SECTION 4.55(1A) APPLICATION TO AMEND SSD 10376 | 125 BATHURST STREET SYDNEY

This letter has been prepared by Urbis on behalf of Pitt Street Developer South Pty Limited (the applicant) in support of a Section 4.55(1A) application to modify SSD 10376 which applies to the Pitt Street South Over Station Development (OSD) at 125 Bathurst Street, Sydney.

The application seeks to revise the maximum RL building height of the development, relocate louvres from the southern façade to the western facade, revise the adaptable apartment floor plans, and add a window on Level 7 of the approved State Significant Development (SSD). The application has been prepared in accordance with the *Environmental Planning and Assessment Act 1979* (EP&A Act) and *Environmental Planning and Assessment Regulations 2000* (the Regulations).

**PITT STREET SOUTH OVER  
STATION DEVELOPMENT (PSS OSD)**  
SSDA Issue  
L06 - GENERAL ARRANGEMENT PLAN

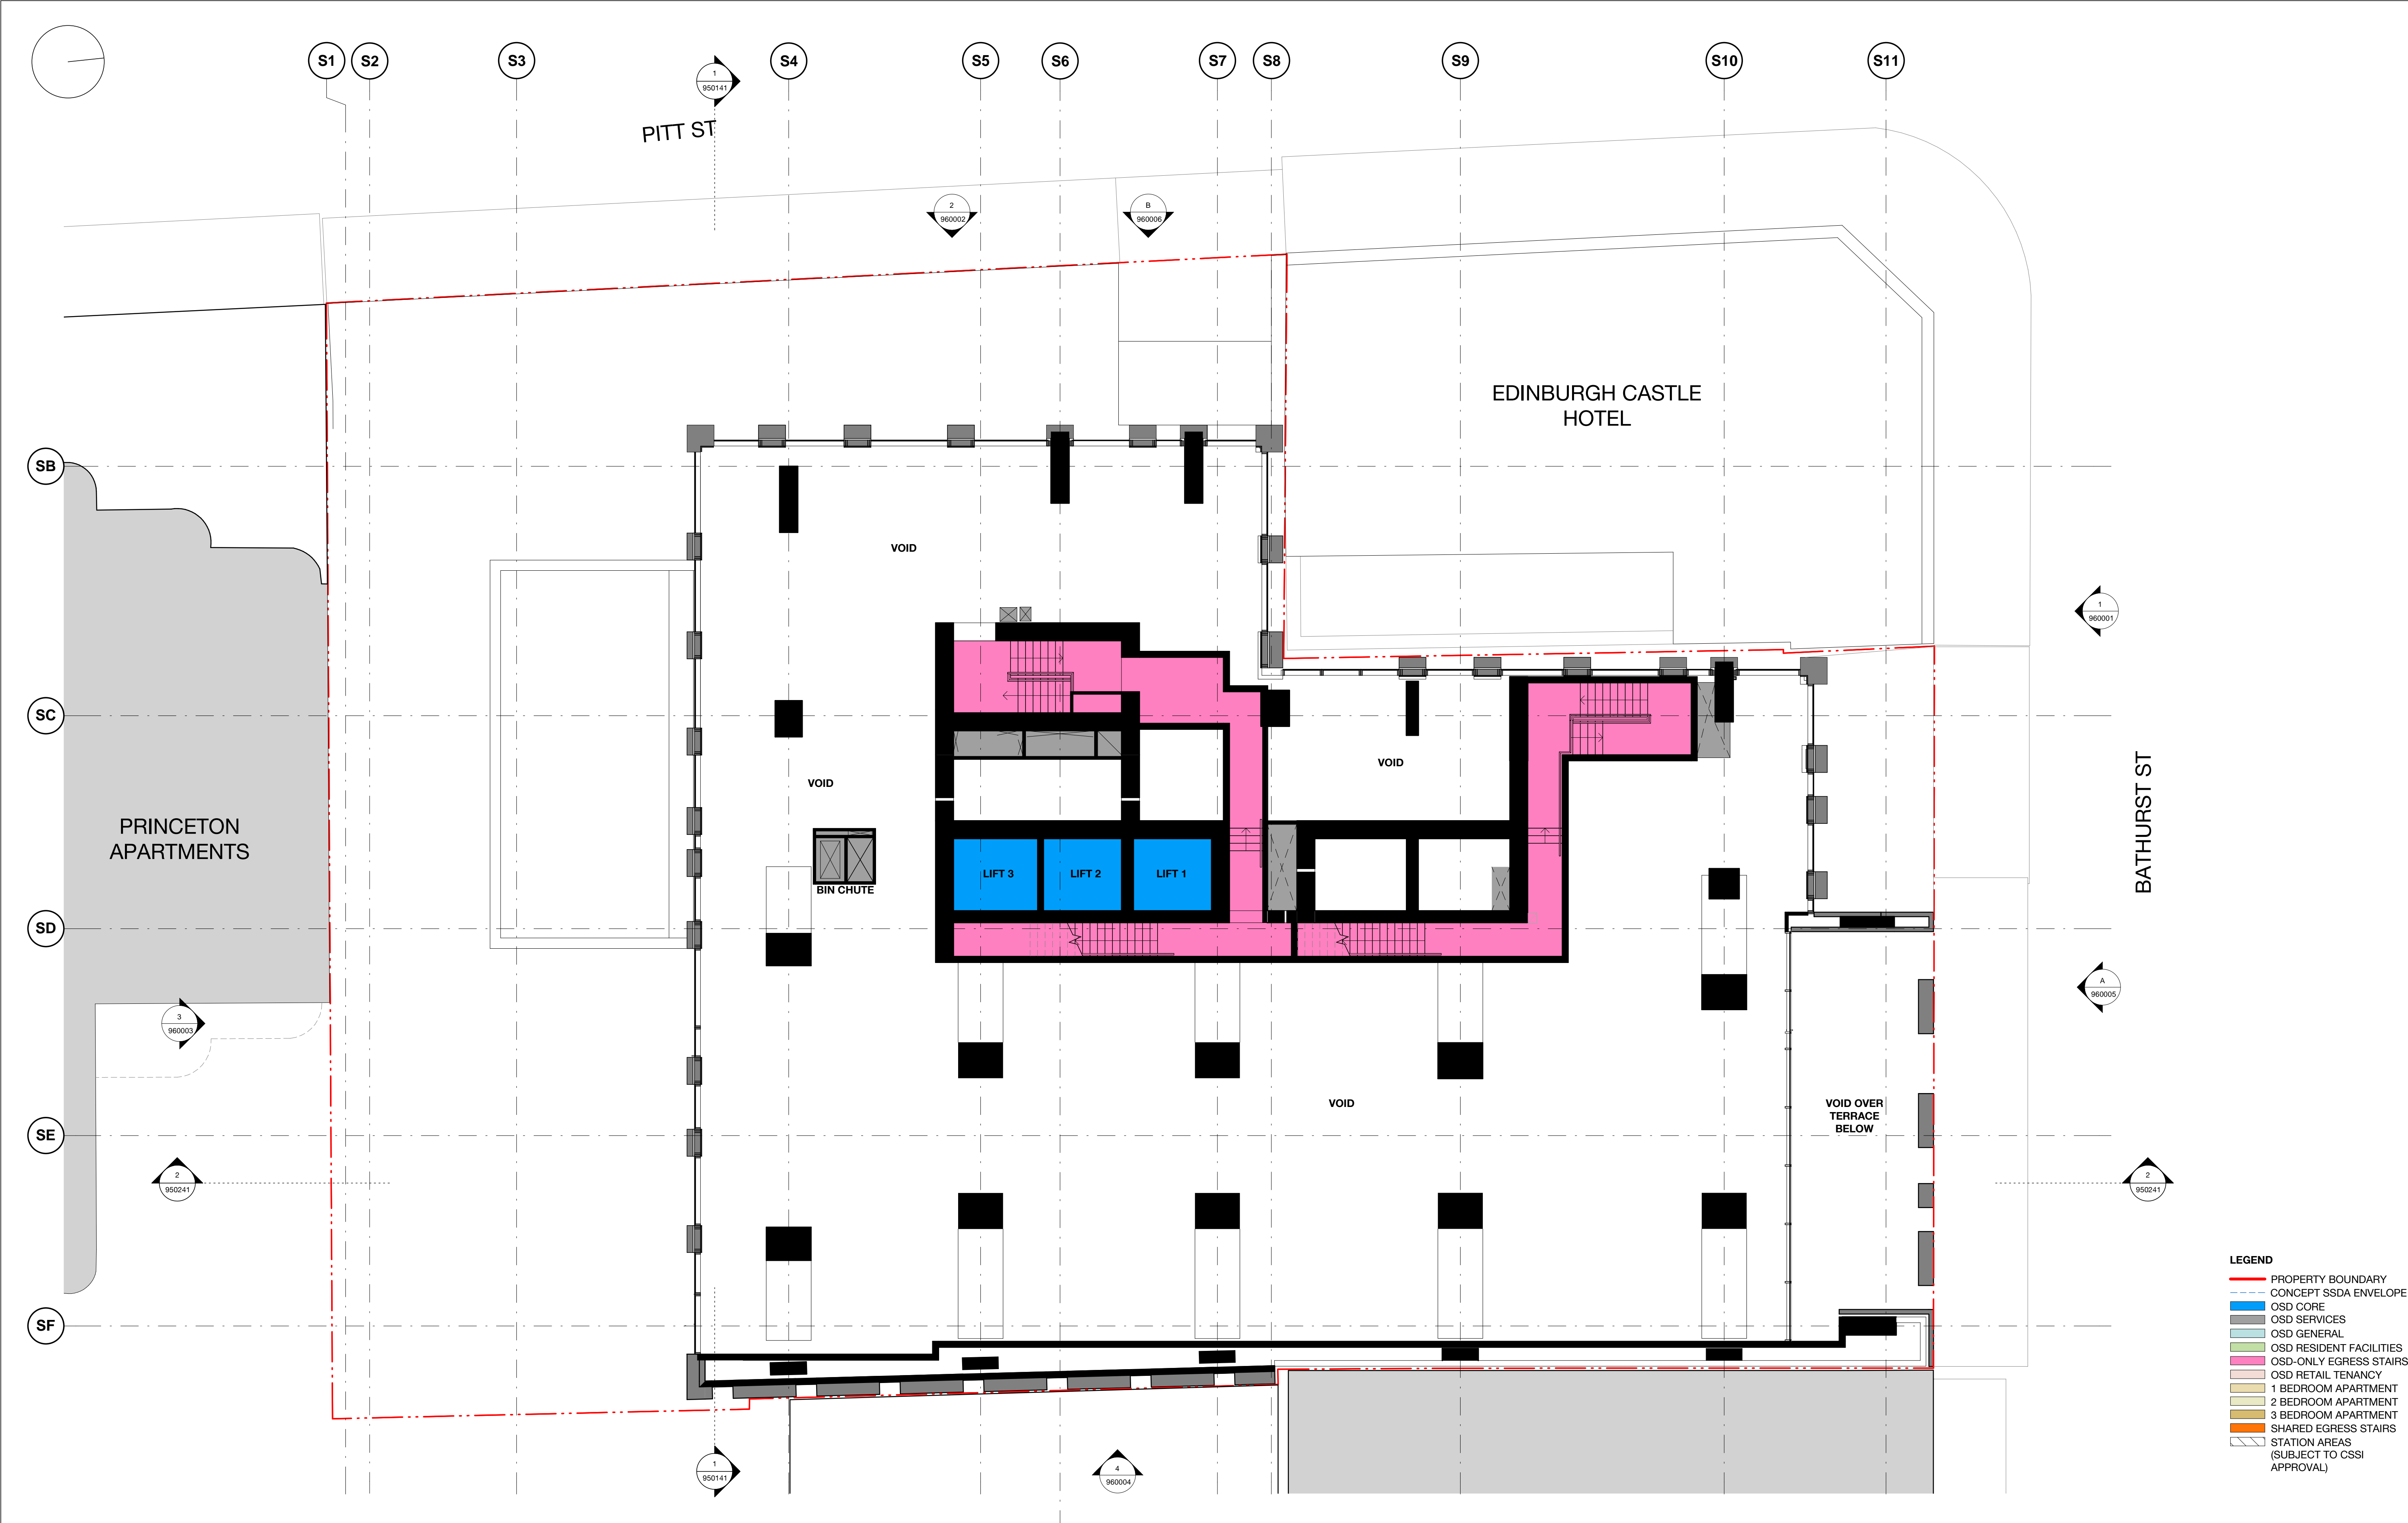
- Revise the approved plans to delete louvres on the southern façade at level 06 and relocate louvres to the western façade of the plant at level 06.

Updates provided in the Architectural Plan reflect the revised louvre location illustrated in **Figure 3**. This is a minor change to the window façade and is necessary due to the stair pressurisation intake being relocated.

DRG No. SMCSWSPS-BAT-OSS-AT-DWG-960004		
<b>PITT STREET SOUTH OVER STATION DEVELOPMENT (PSS OSD)</b>		
SSDA Issue EAST ELEVATION		
STATUS: SSDA Issue	SHEET OF	©
METRO DRG No.		REV . K

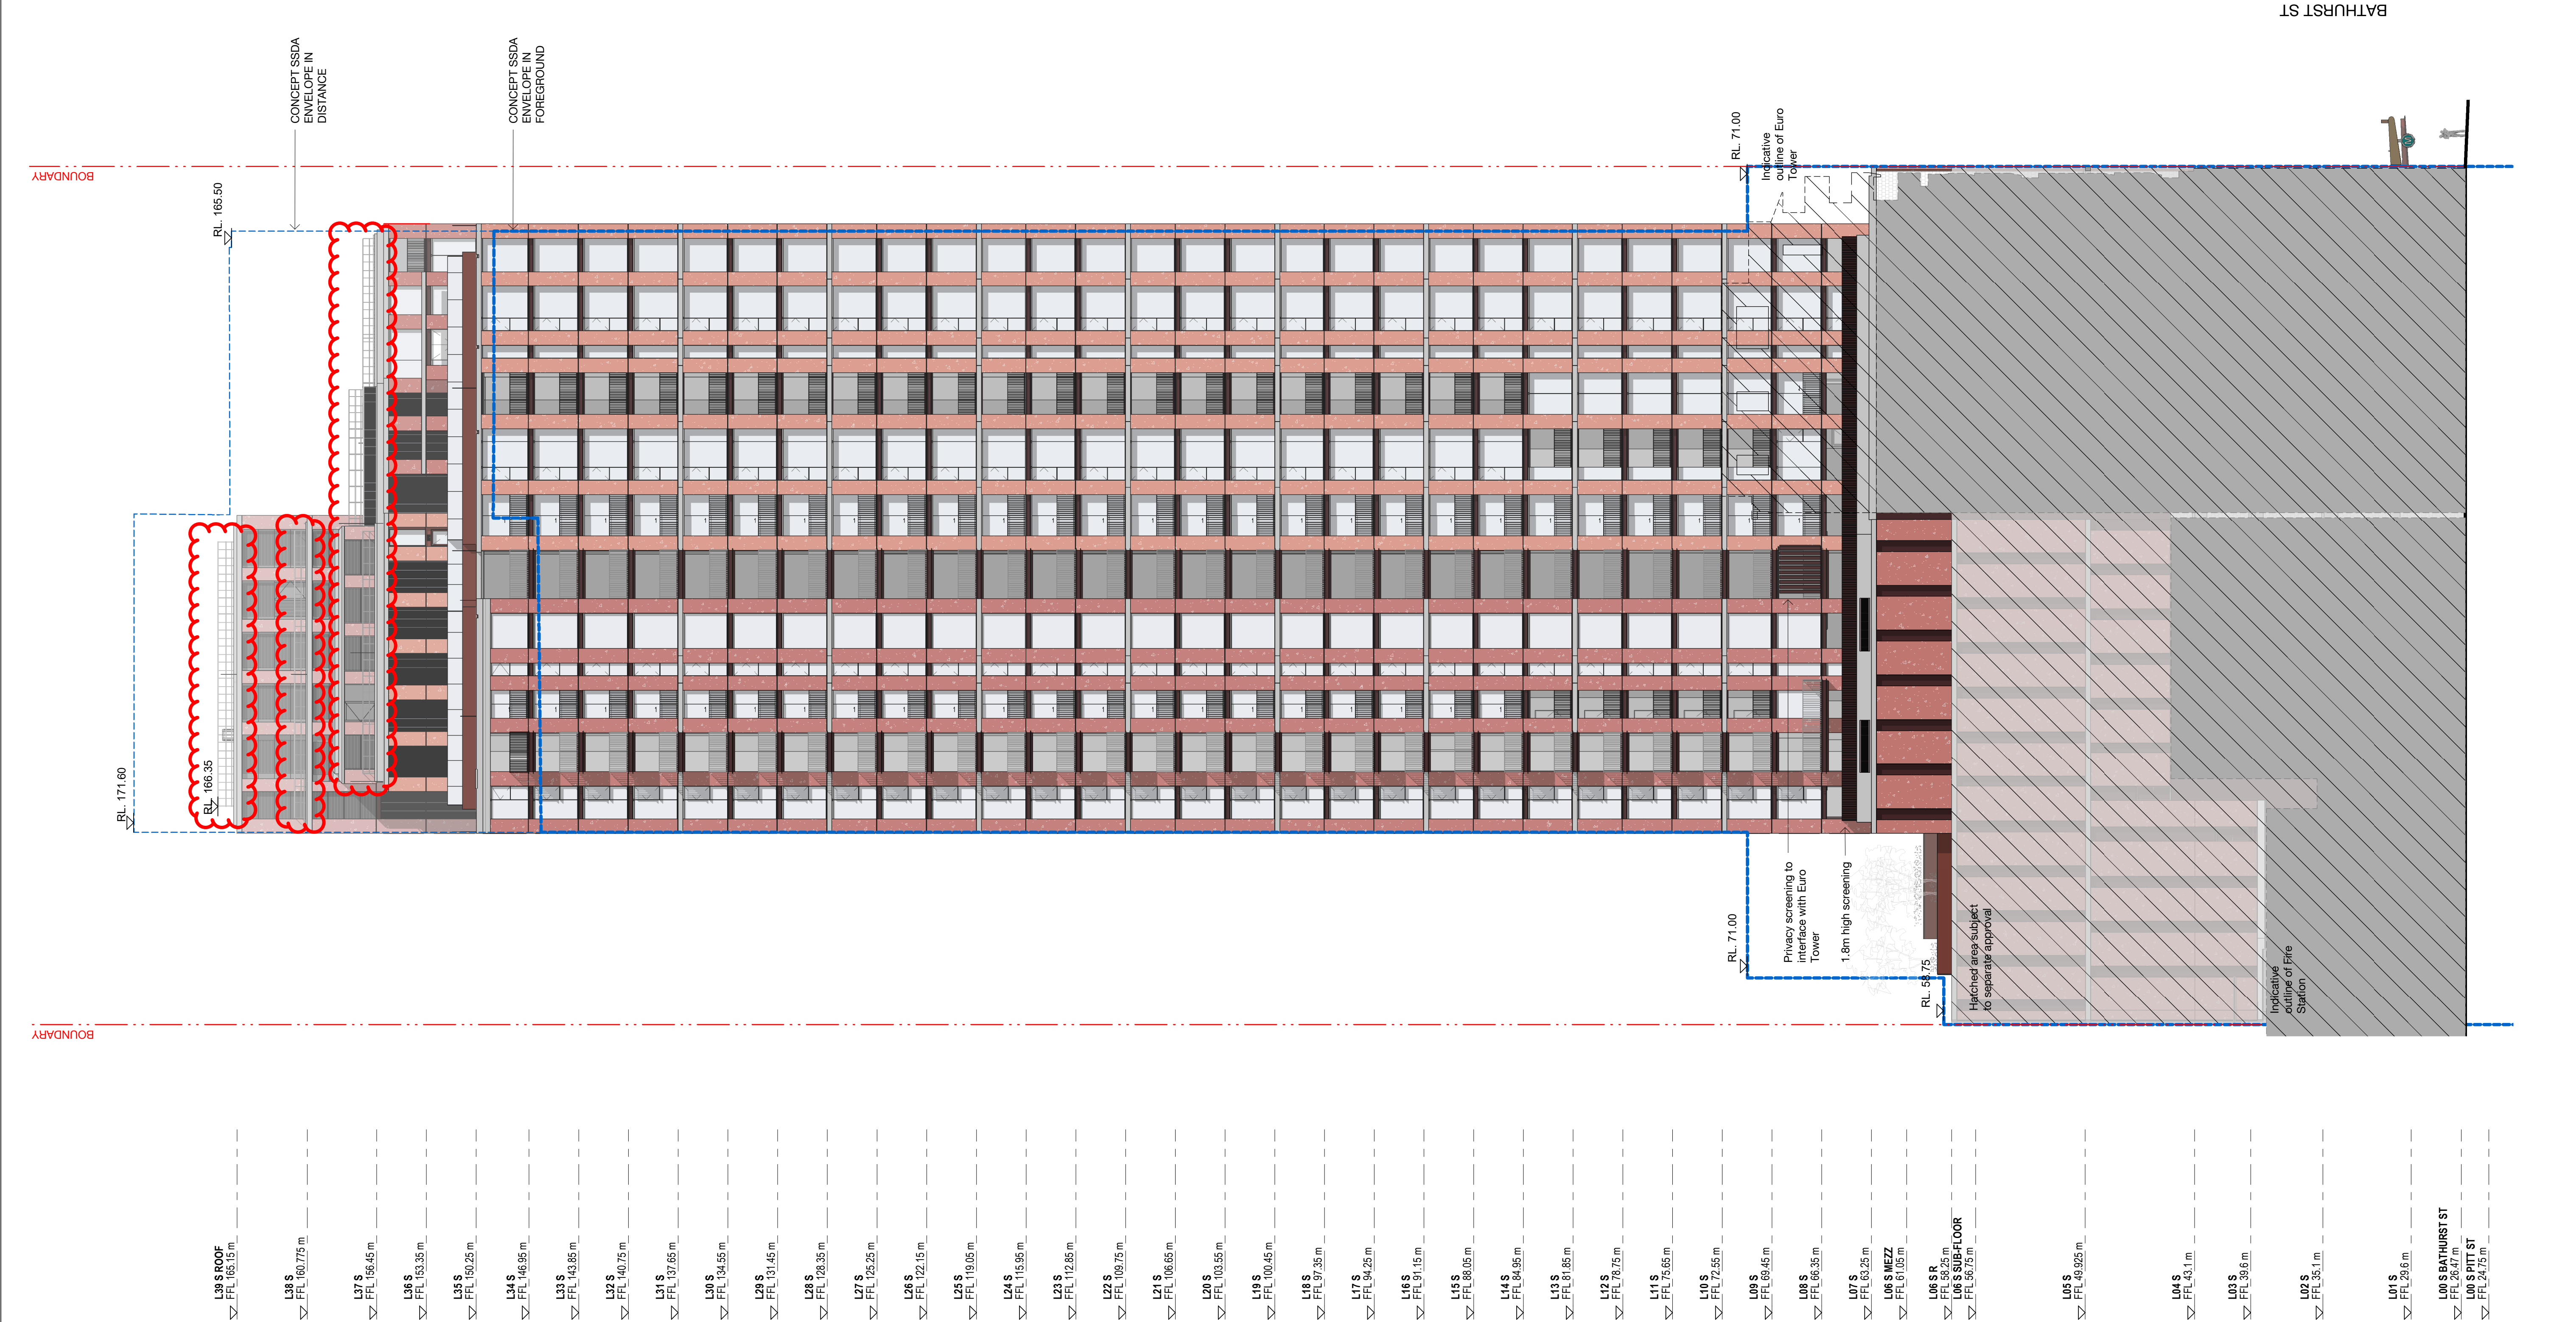
The maximum building height permitted by condition B11 requires minor uplift from RL165.35 to reach an overall height of **RL166.35** to allow for the building envelope to include:

- Two hot water generator flues protruding 600mm above RL165.35
- Six air terminals protruding 800mm above RL165.35
- Top of handrail protruding 1m above RL165.35

The Architectural Plan illustrating the proposed components of the building that will exceed RL 165.35 within this amendment is illustrated in

*B11. The maximum height of the approved building must not exceed RL 165.35 m AHD, including plant and lift overruns. **Communication devices, antennas, satellite dishes, masts, flagpoles, chimneys, flues, balustrades** and the like **may extend to a maximum height of RL 166.35**. Details confirming compliance with this condition must be submitted to the Certifying Authority prior to the issue of the relevant Construction Certificate.*
